KIRKLEES METROPOLITAN COUNCIL INVESTMENT & REGENERATION SERVICE

Reference No:	2024/62/92907/W
Site Address:	16, Greenhead Avenue, Dalton, Huddersfield, HD5 8EA
Description:	Erection of two storey side and single storey rear extensions
Recommending Officer:	Molly Storer

HOUSEHOLDER DELEGATED REPORT

Application Number	2024/92907
Location	16, Greenhead Avenue, Dalton, Huddersfield, HD5 8EA
Proposal	Erection of two storey side and single storey rear extensions.
Publicity end date	25 th November 2024
Number of representations received	One. This will be discussed in the representations section of the report.
Kirklees Local Plan Allocation/Designation	Unallocated in the Kirklees Local Plan
Extension to Time (EoT)	No
Recommendation	Conditional Full Permission

SOUTH EAST ELEVATION - 1:100
GREENHEAD AVENUE
PROPOSED

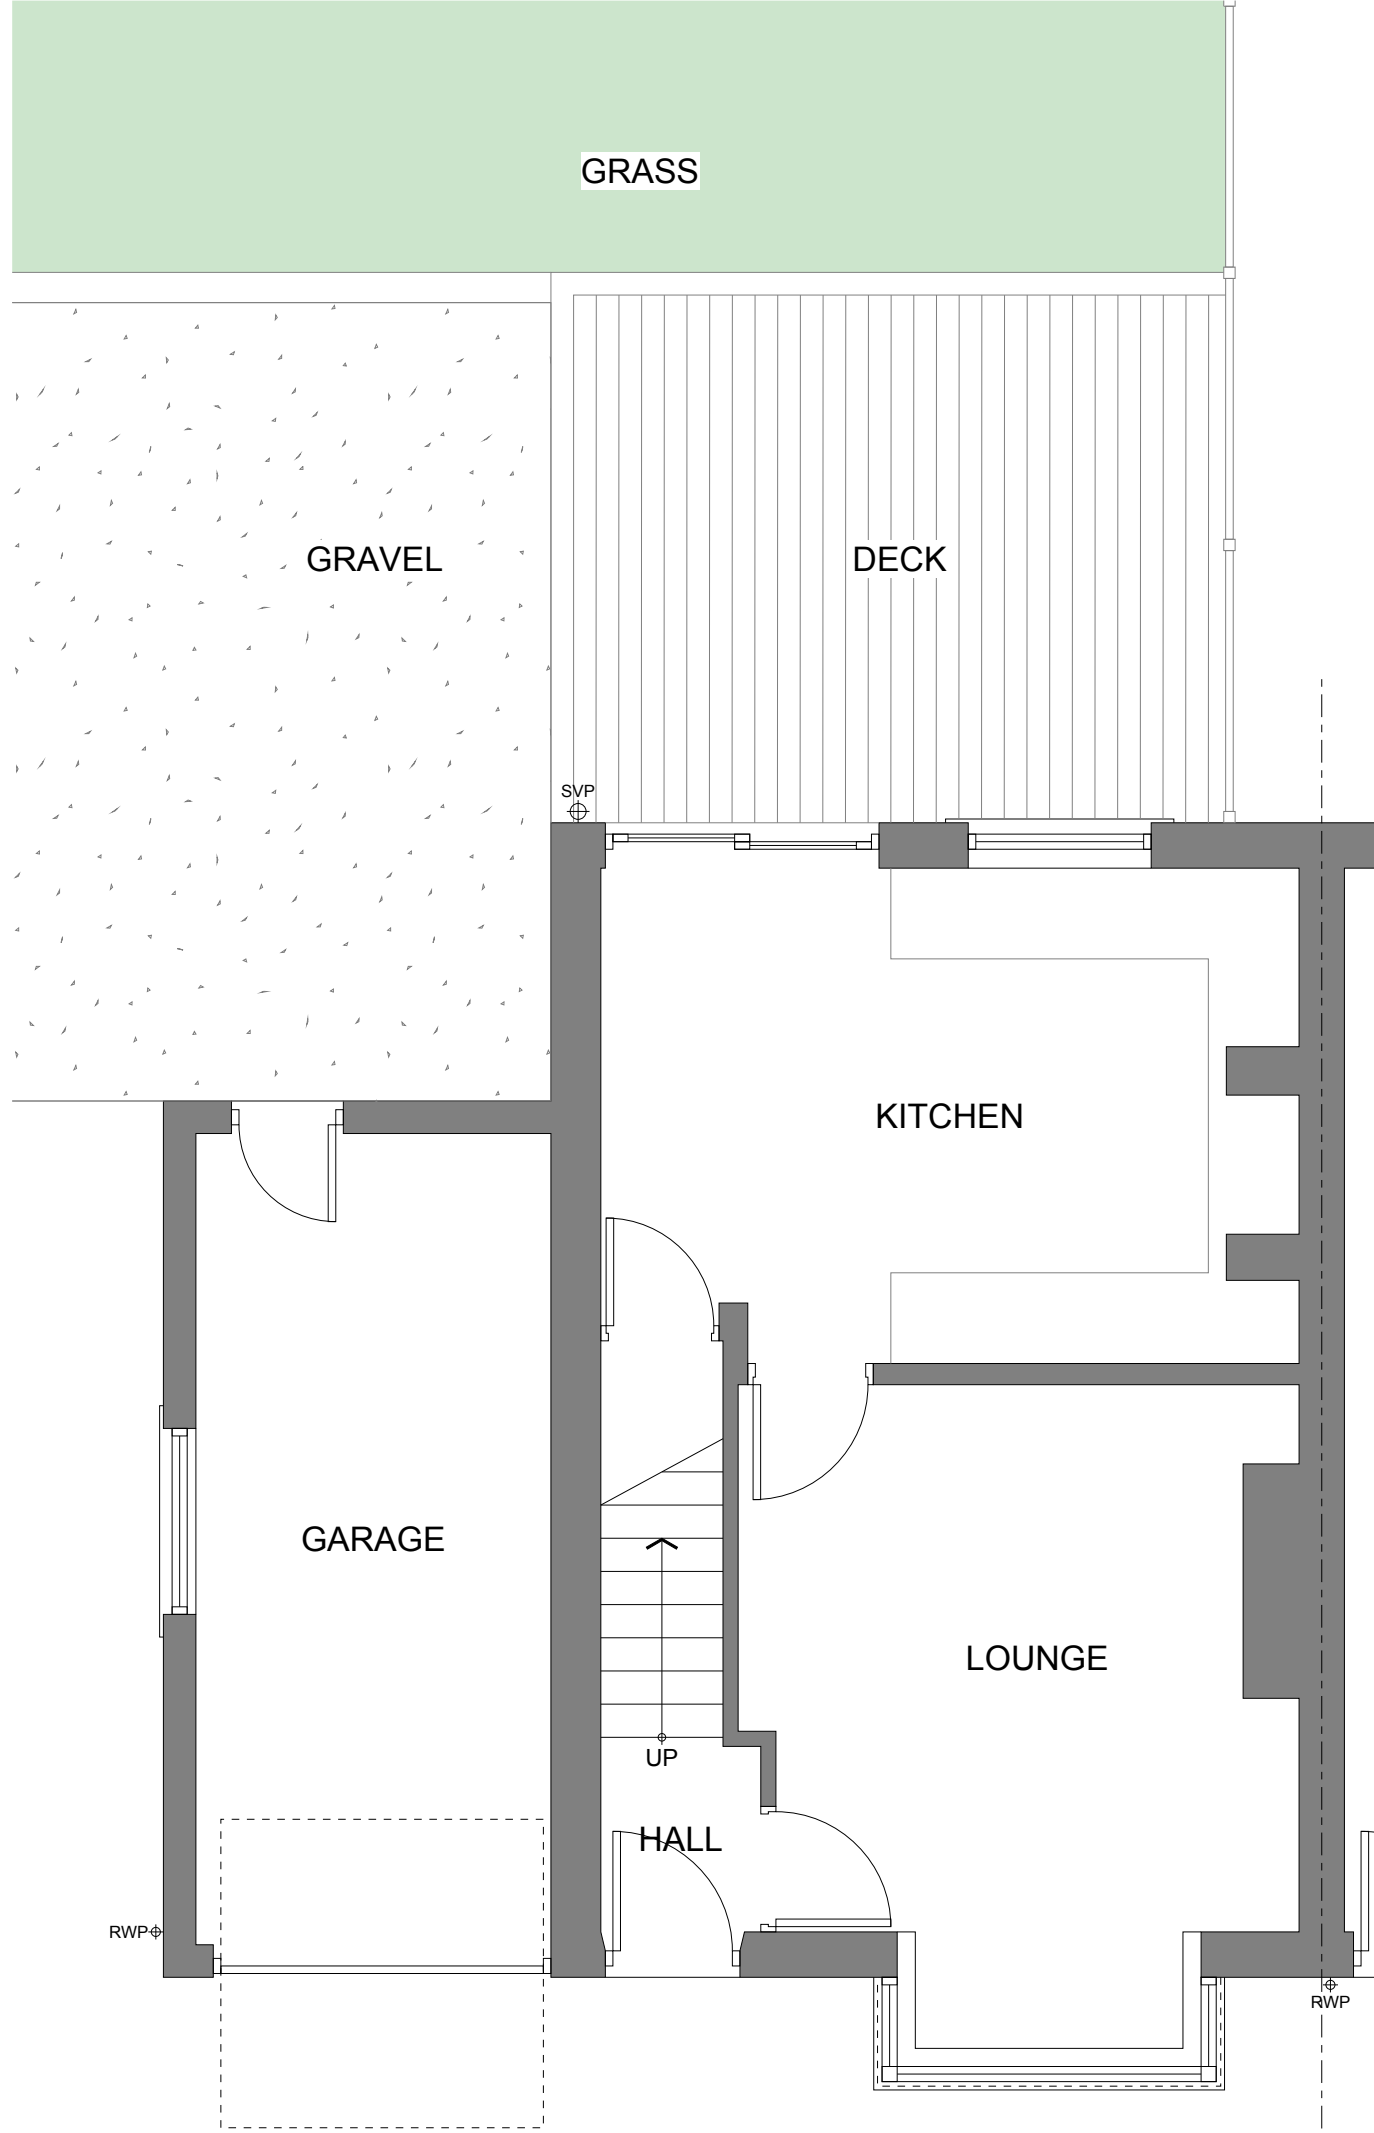
YES / NO	SUMMARY
Negotiations/Amendments during course of application	Yes	The original submitted scheme raised concerns regarding the two storey side extension. It was recommended that the side extension be set back by 0.5m behind the front elevation of the

existing dwelling and down from the roof ridge of the original house in line with the SPD. The agent submitted amended plans showing this. These plans will be assessed in the following report.
Parish/Town Council comments sought	No	
Planning History	No	
Consultations required	No

Relevant key design principle (KDP) of the SPD, Policy in the Kirklees Local Plan and the NPPF	Further comments	✓ / X / N/A
Impact on the Local character and street scene	• KDP1 of the SPD • Policy LP24 Design (a) and (c) of the KLP	As the side extension has been amended to be set in and set down from the original house it now creates a visual break from public viewpoints.	✓

Not take up all or most of the space to the side of a house	Yes – the extension is set in from the side boundary of the property by 0.7m.	
maintain a 1 metre gap to the side boundary to ensure the building is not too close to a neighbouring property		No - a gap of only 0.7m would be maintained to the property boundary however there are no neighbouring properties directly adjacent to the southwest so this 0.3m shortfall is considered acceptable.
be set back at least 500mm from the front wall of the house	Yes – the amended plans show the extension is set back from the front elevation of the property by than 500mm

GROUND FLOOR PLAN - 1:50
PROPOSED

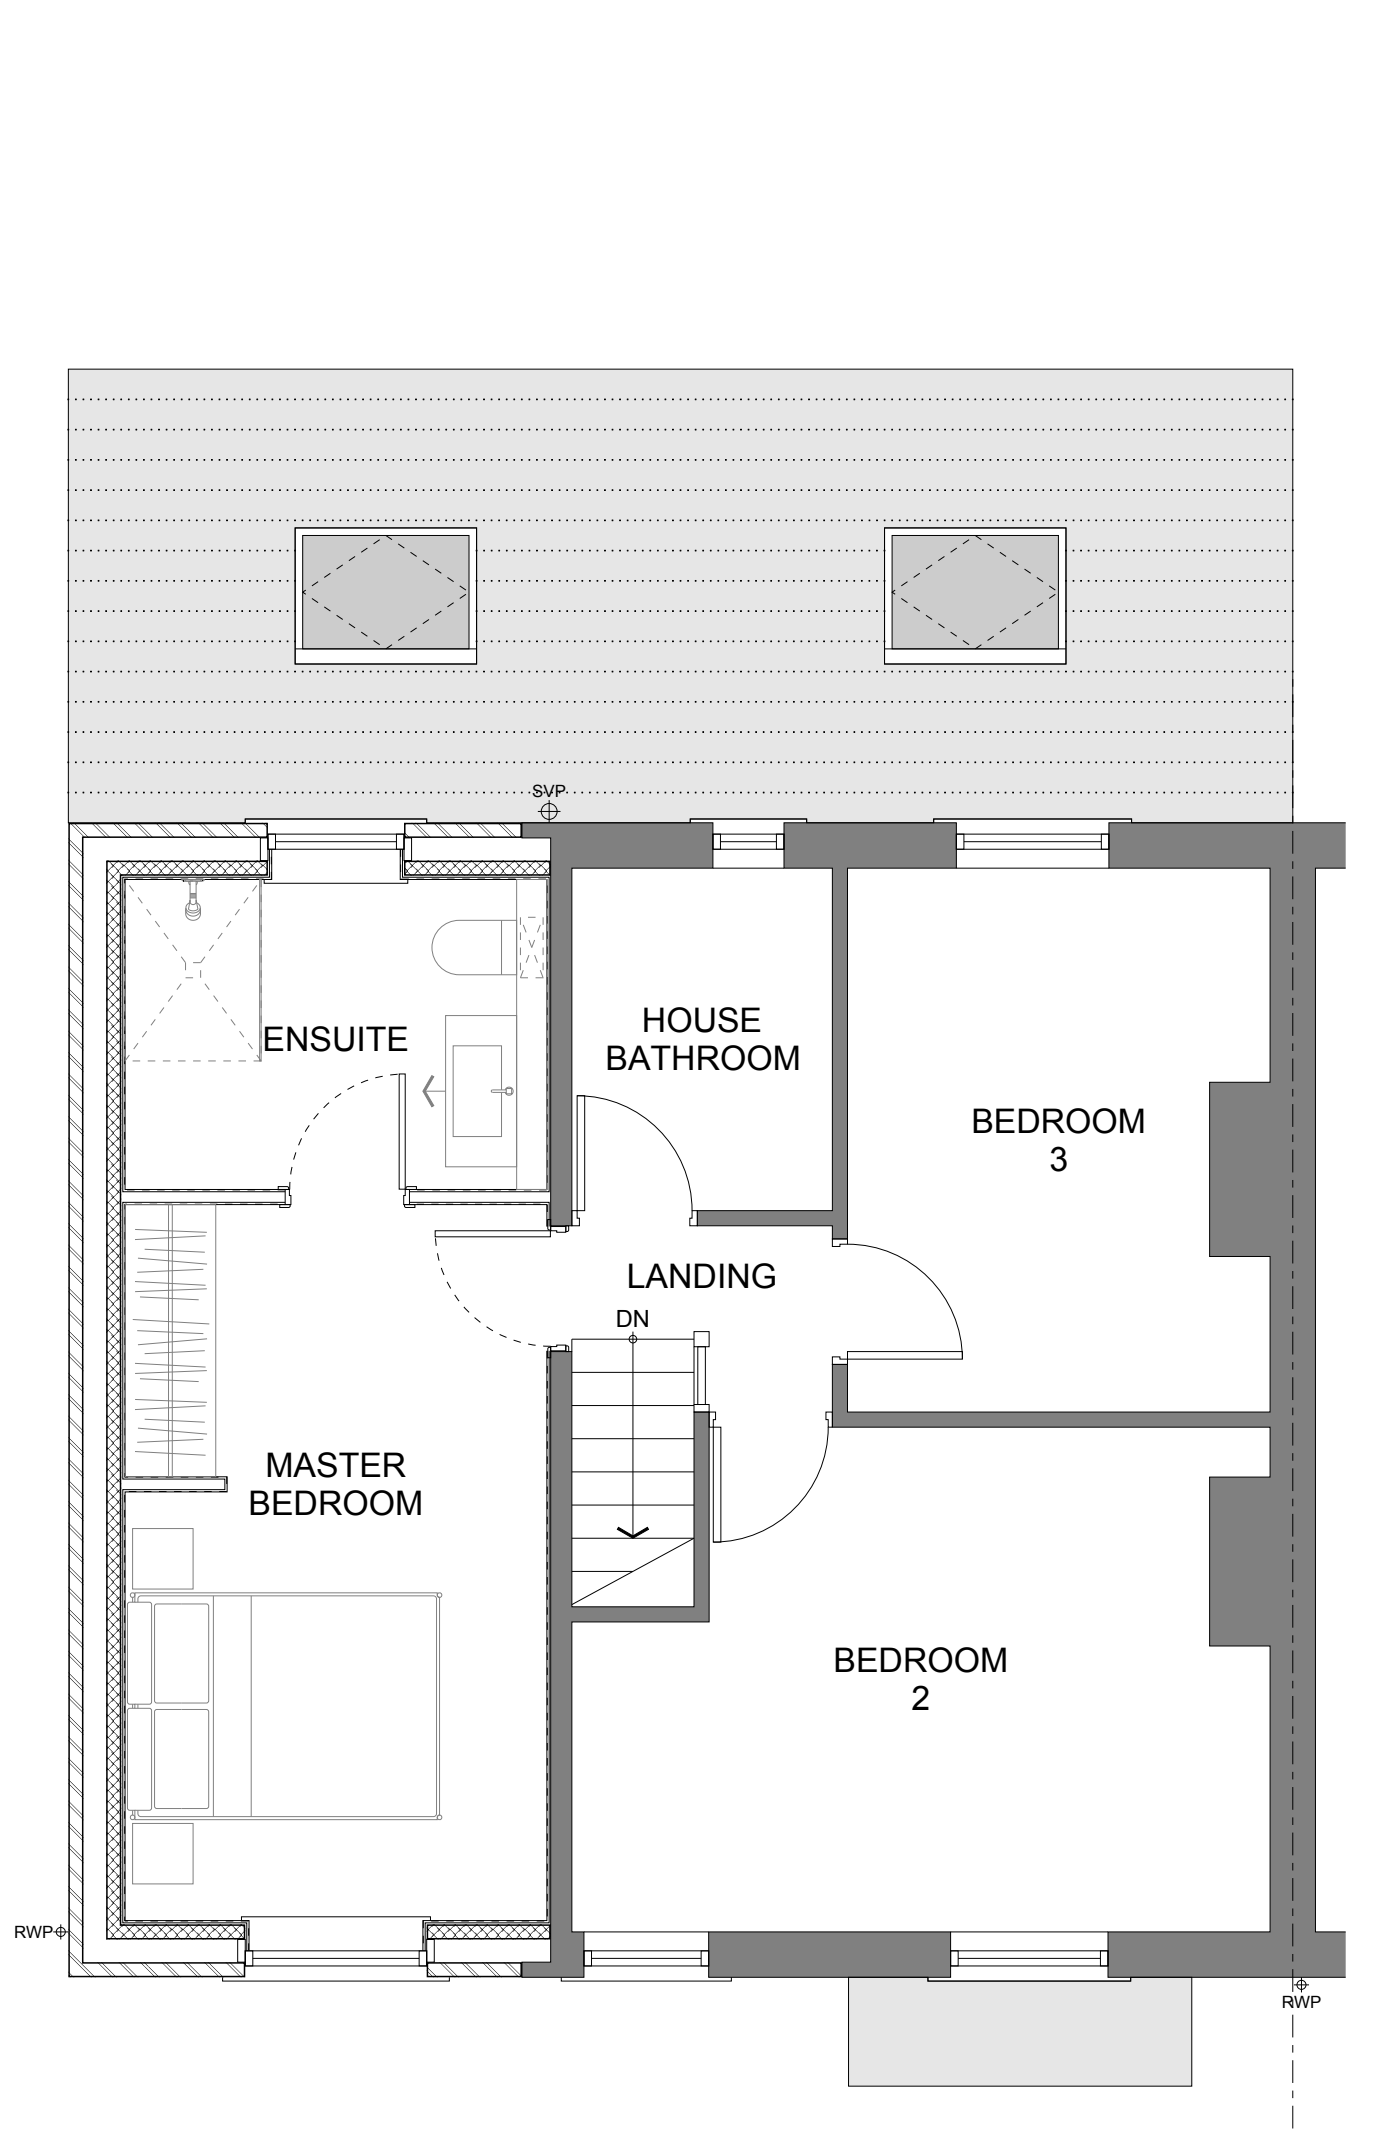
The single storey rear extension will project 3m from the rear wall of the house and will have a span across the rear of 8.15 meters, it will have a lean-to roof design with an overall height of 3m to the eaves and 4m to the topmost part of the roof.

by 4 metres for detached properties	than 3 meters from the rear wall.	
where they exceed 3m in length the eaves height should generally not exceed 2.5 meters	Yes – the projection would not exceed 3m. Eaves being 3m.	
retain a gap of at least 1 metre from a property boundary, such as a wall, fence or hedge		No – the extension would be on the boundary line with No.14. However, weight is given to the PD fallback option of the single storey rear extension.

BLOCK PLAN - 1:500
PROPOSED

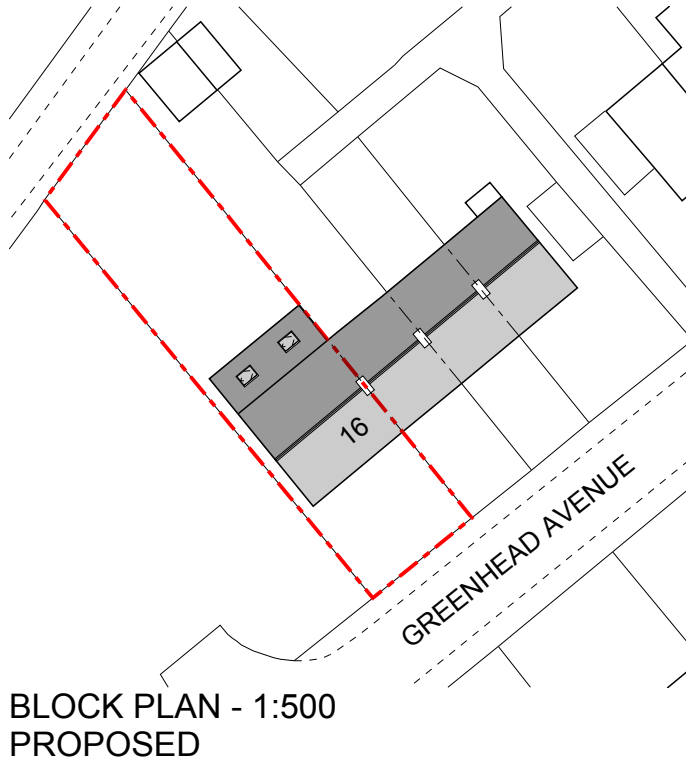
with a general principle that at least half the garden area is retained	and rear more than half of this will be retained as amenity space. Usable private amenity space would be provided.	
Be set behind the original building, and not projecting beyond the sides		No – although the rear extension would project to the side of the property this would not project further than the two storey side extension which will be assessed later in the report.
Maintain external access to the rear garden	Yes – external access would be maintained.	
Single storey rear extensions should:		
be in keeping with the scale and style of the original house	Yes – due to being single storey in height and having a limited projection considered to be keeping with the scale of the original dwelling. The usage of matching materials means the extension is considered to be in keeping with the style of the original house.	
not normally cover more than half the total area around the original house (including previous extensions and outbuildings)	Yes – does not cover more than half of the total area around the original house.
